# 88 Walker Street, North Sydney

## Response to Submissions

SOLAR STUDY DIAGRAM.

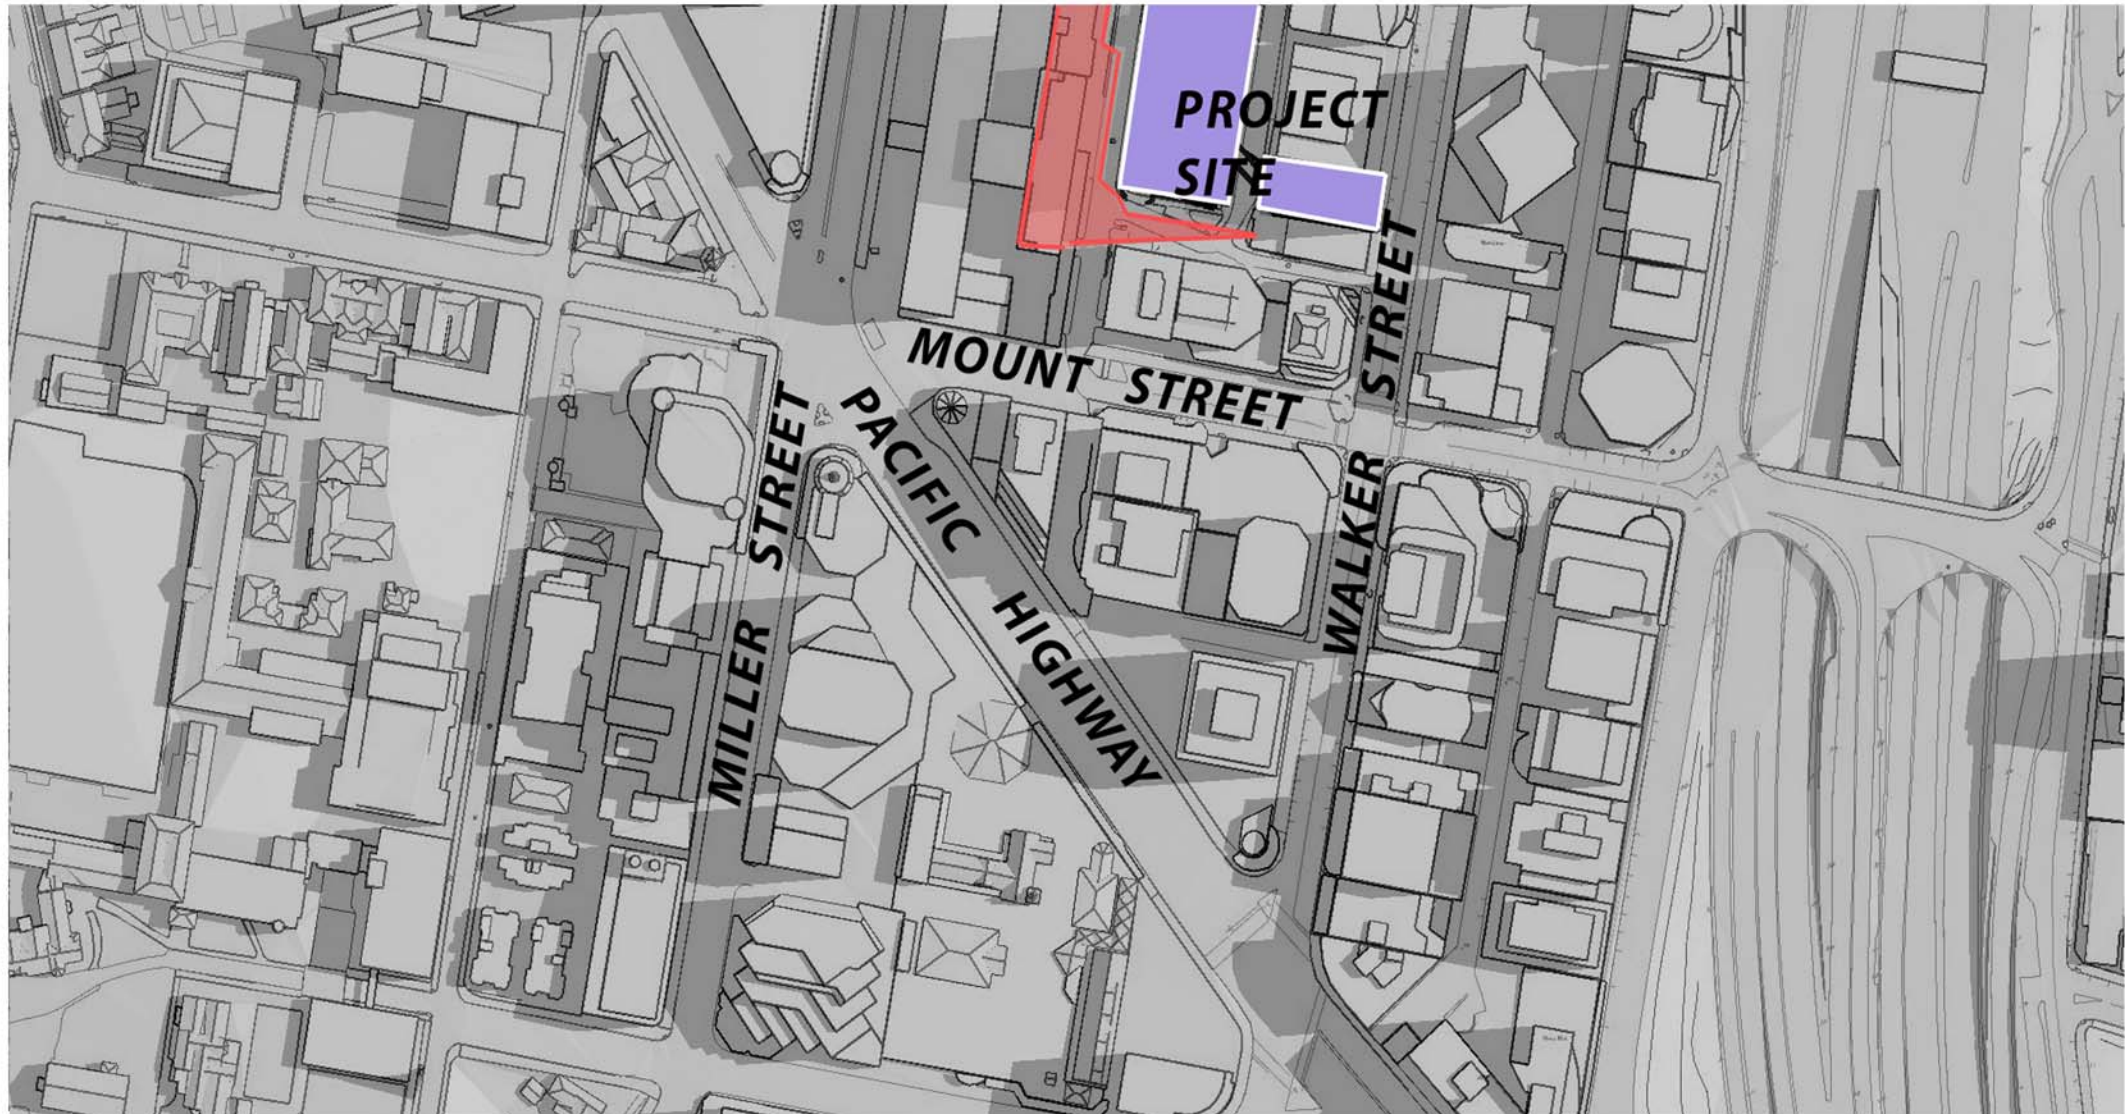
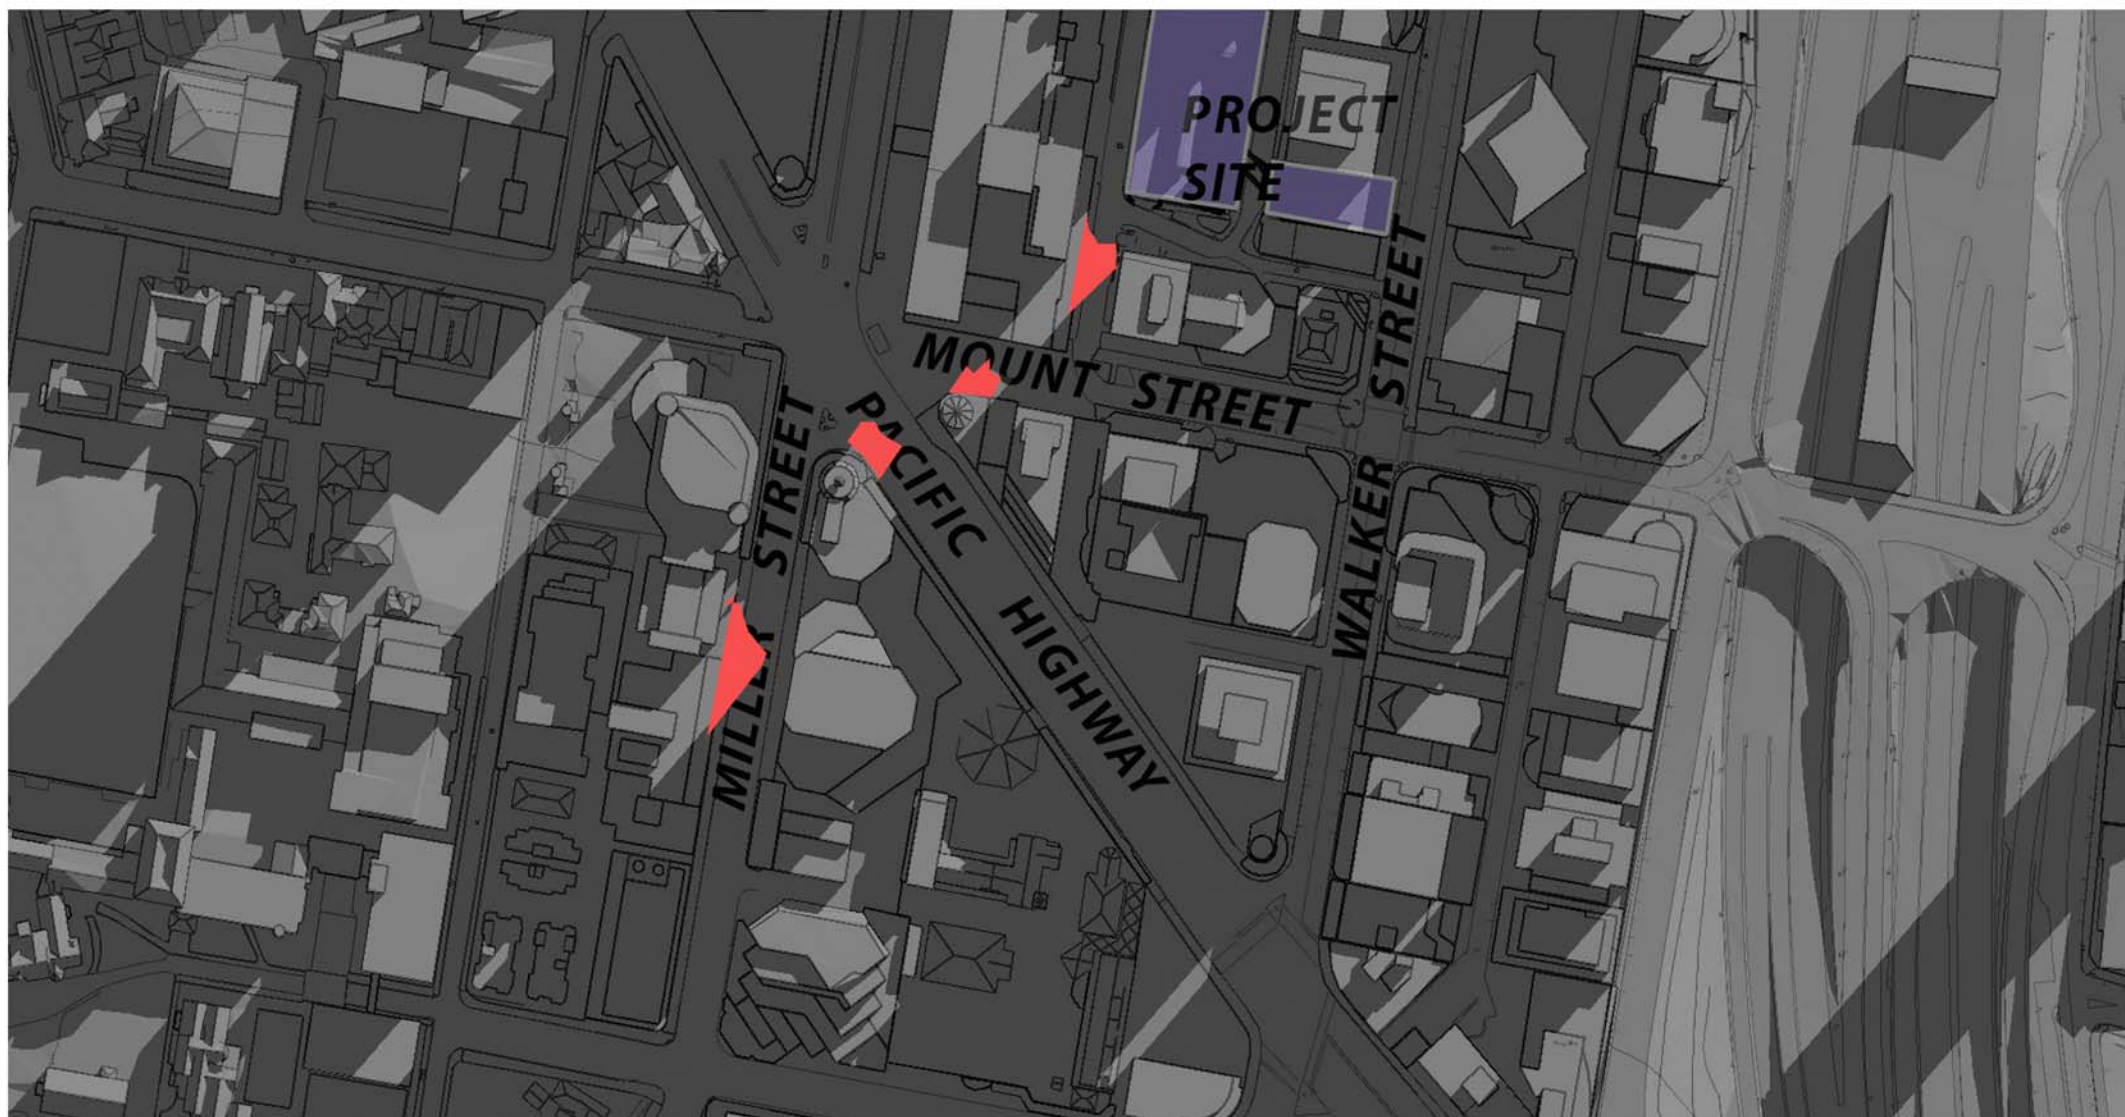
Submission	Key Issue Raised	Response
	45. Inadequate assessment of overshadowing of dwellings outside the CBD as diagrams do not show the existing overshadowing of the affected properties.	Additional shadow diagrams have now been prepared, refer to <b>Section 3</b> and <b>Appendix D</b> of the PPR.

1. Existing views from penthouse (Level 36) of Beau Monde looking south east

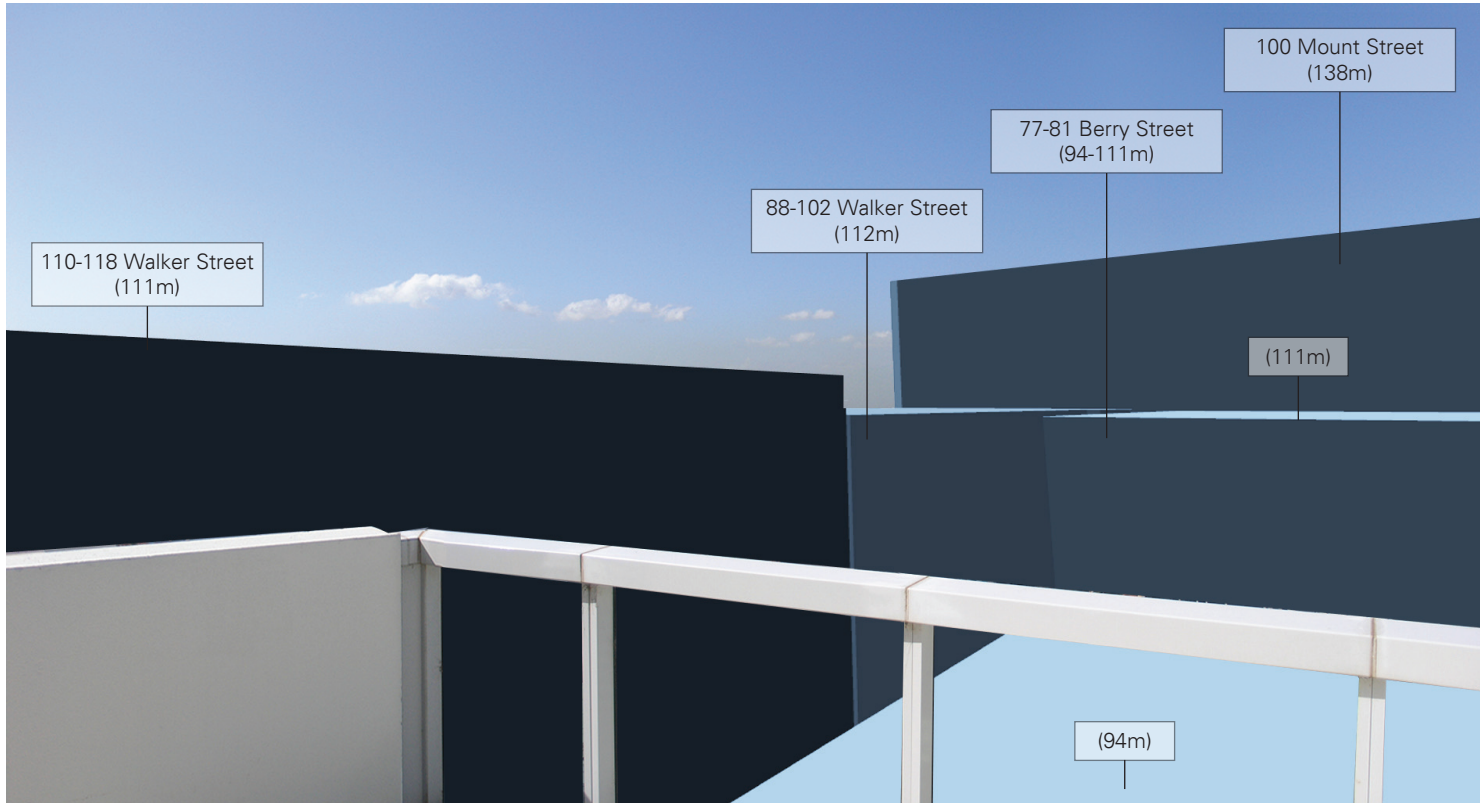
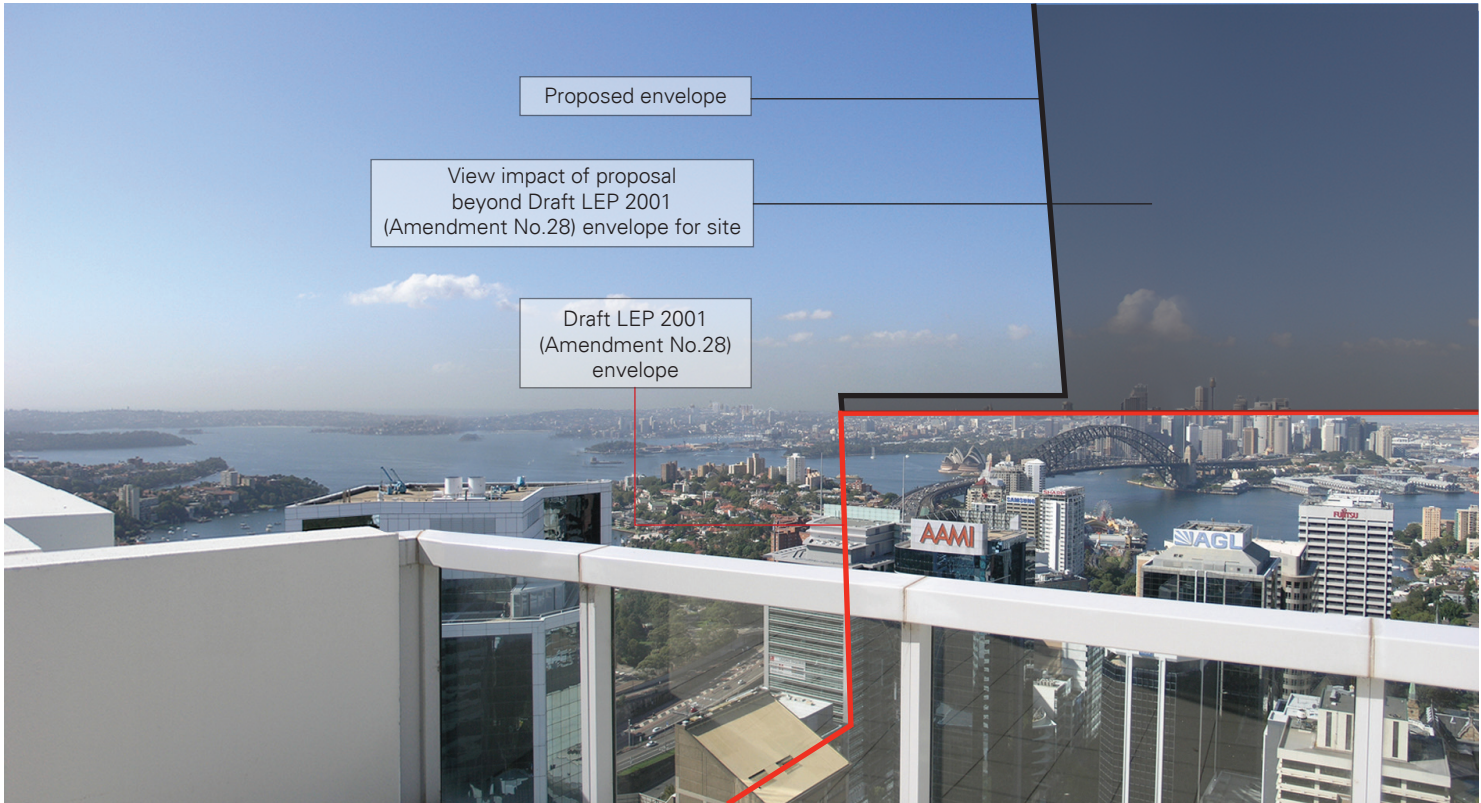
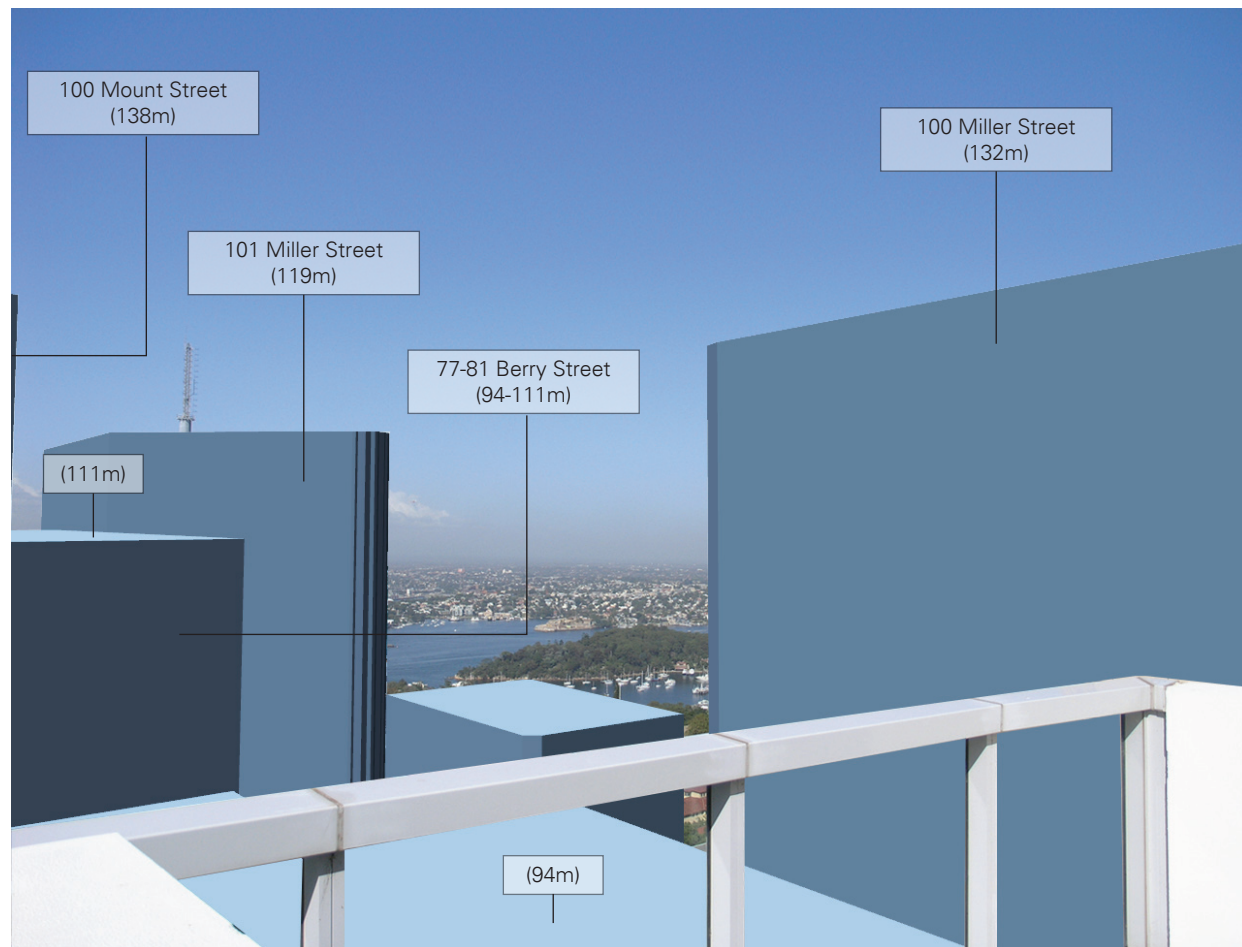
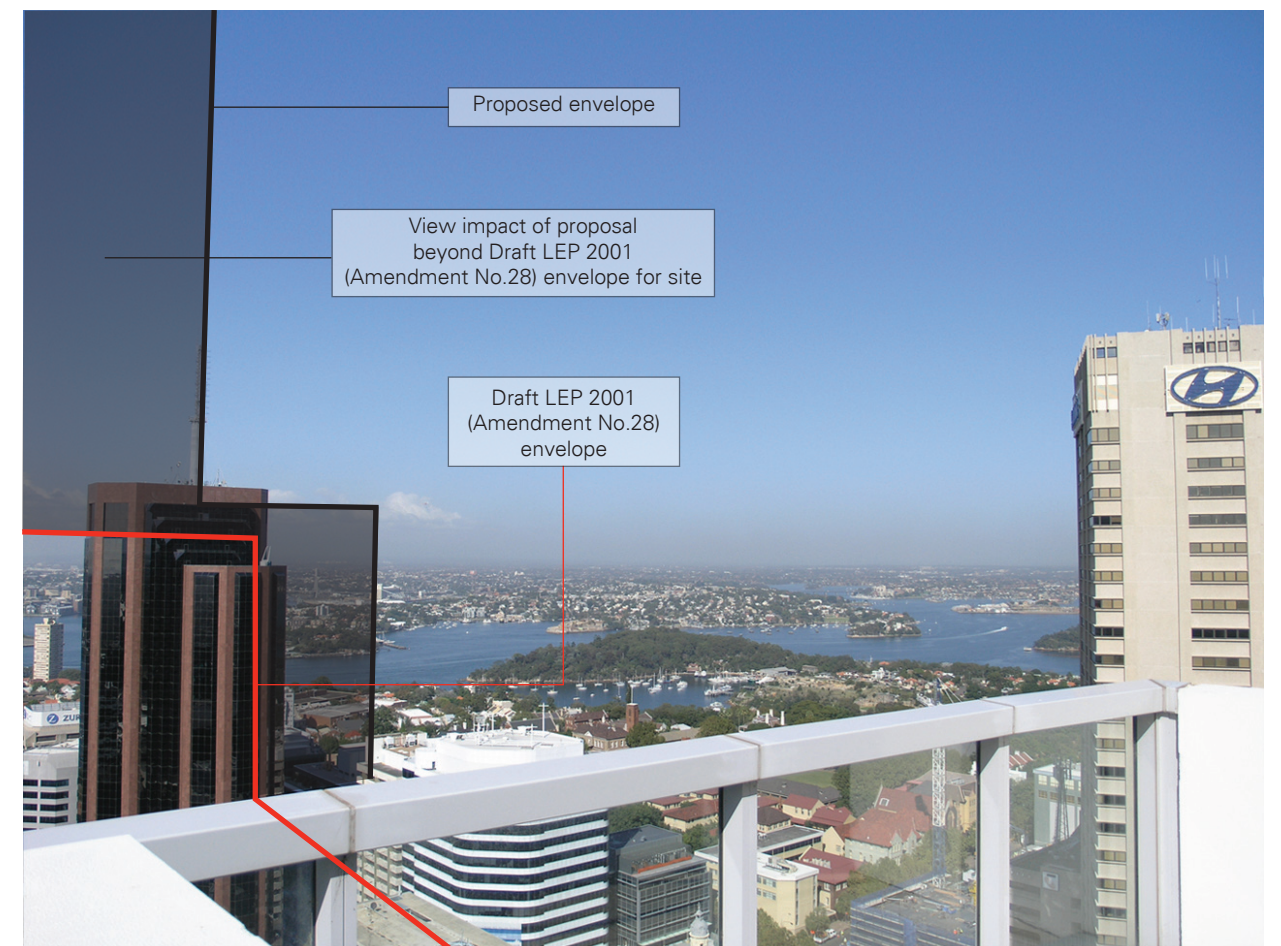
<p>22. The non-compliances with Council's building height and massing controls (both existing and draft) will result in significant to devastating view loss for adjoining residential dwellings above RL170 (being the exhibited maximum height in Draft Amendment 28 to LEP 2001) on the northern portion of 77 Berry Street, North Sydney (Beau Monde).</p>	<p>A detailed discussion on view impacts is provided in <b>Section 6</b> of the PPR and <b>Appendix F</b>.</p>
	<p>23. The proposed public benefits are inadequate. The proposed public domain works are entirely on Council owned land and of a type normally expected for a development of this size. The developer proposes to deduct the costs of the public domain works from the s94 contributions Council would expect if it were the consent authority. The proposed public benefits do not satisfy clause 28D (5) (b) of LEP 2001 as the proposal does not include community facilities, child care centres or the like.</p>	<p>The value of the public benefits proposed exceed that which would normally be payable under Council's Section 94 Plan. The provision of the through site link is also a significant public benefit as it allows for the creation of the new public open space in Dennison Street.</p> <p>There is nothing preventing the introduction of a child care centre into the scheme in the future if a suitable operator approaches the proponent.</p>

47. View loss assessment should have regard to the current applicable development controls and not amendment 28 which is far from being certain or imminent	A view impact analysis which assess the impacts of LEP 2001, Draft LEP Amendment 28 and the proposed development is included at <b>Appendix F</b> and discussed in <b>Section 3</b> .
